From:
To: [DCAdmin](#)
Subject: Planning Application Comments for 2022/91929
Date: 01 August 2023 07:10:28

Proposed Floor Plan, Elevations and Location Plan

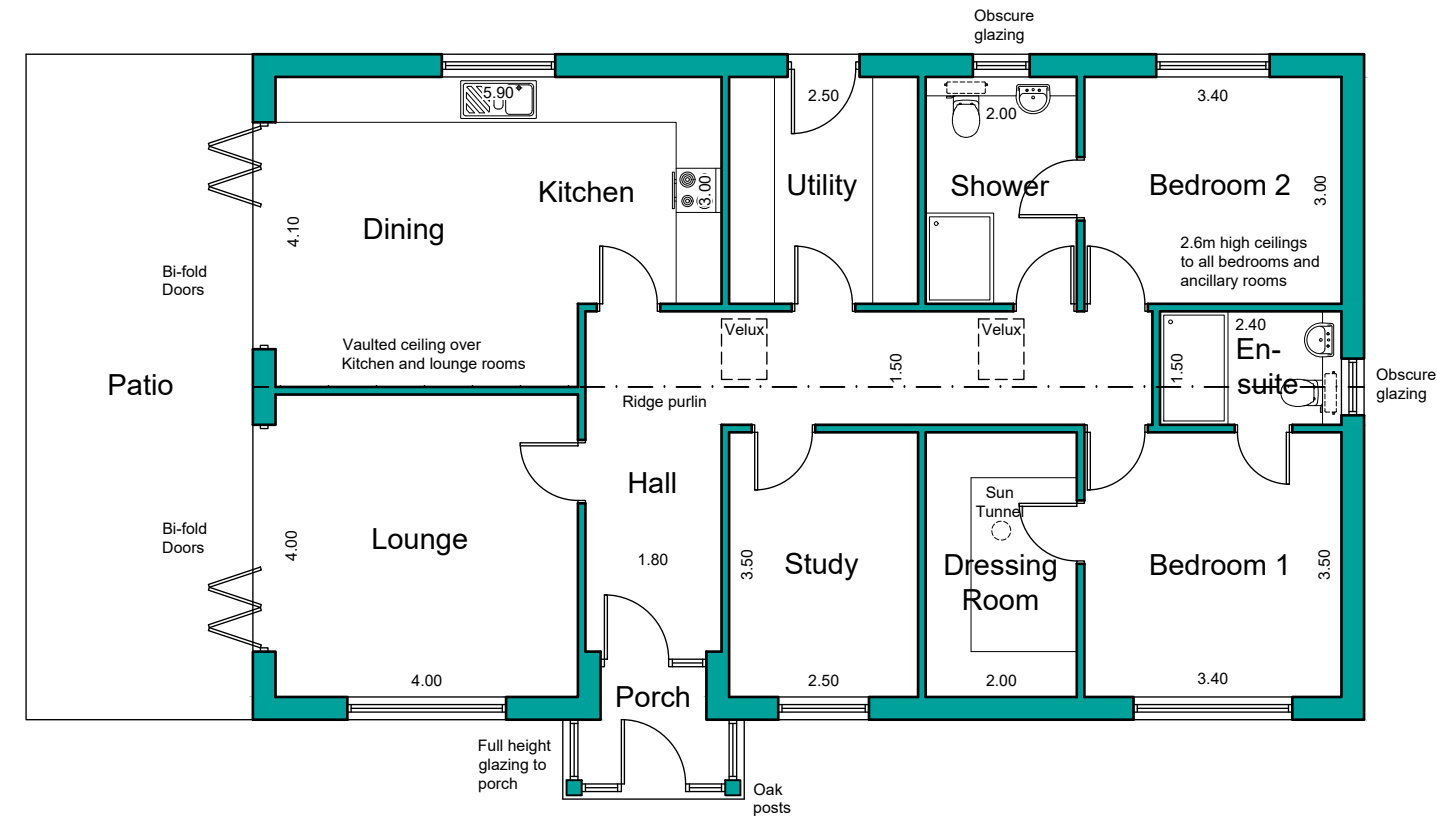
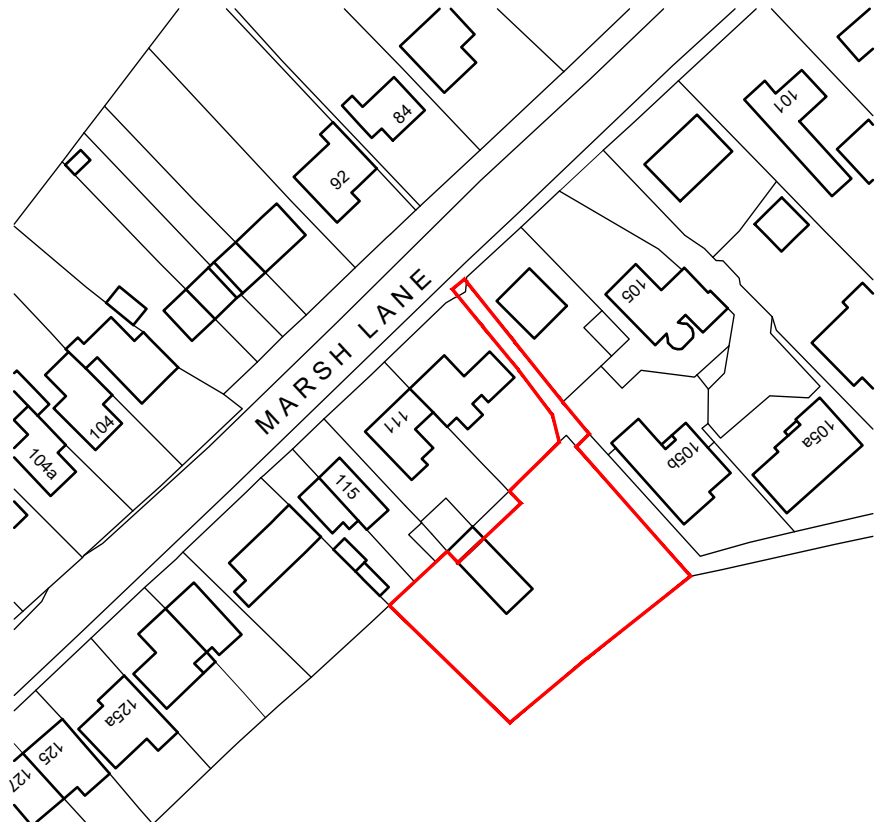
I would like the planning officer to look at the application with regards to my objection to the proximity of the build in relation to the boundary line as I think it is far too close to my property and my boundary wall. This will affect my privacy from my principle windows.

The planned build is also directly under a mature tree which I do not believe is advisable. Can I have assurances that the tree will not be disturbed or affected by the planned build.

I ask that the build is moved back approx. 3m to bring it in line with the neighbouring property.

I would also like to object to the size of the build in relation to the size of the plot as this looks to me to be more than the permitted ratio.
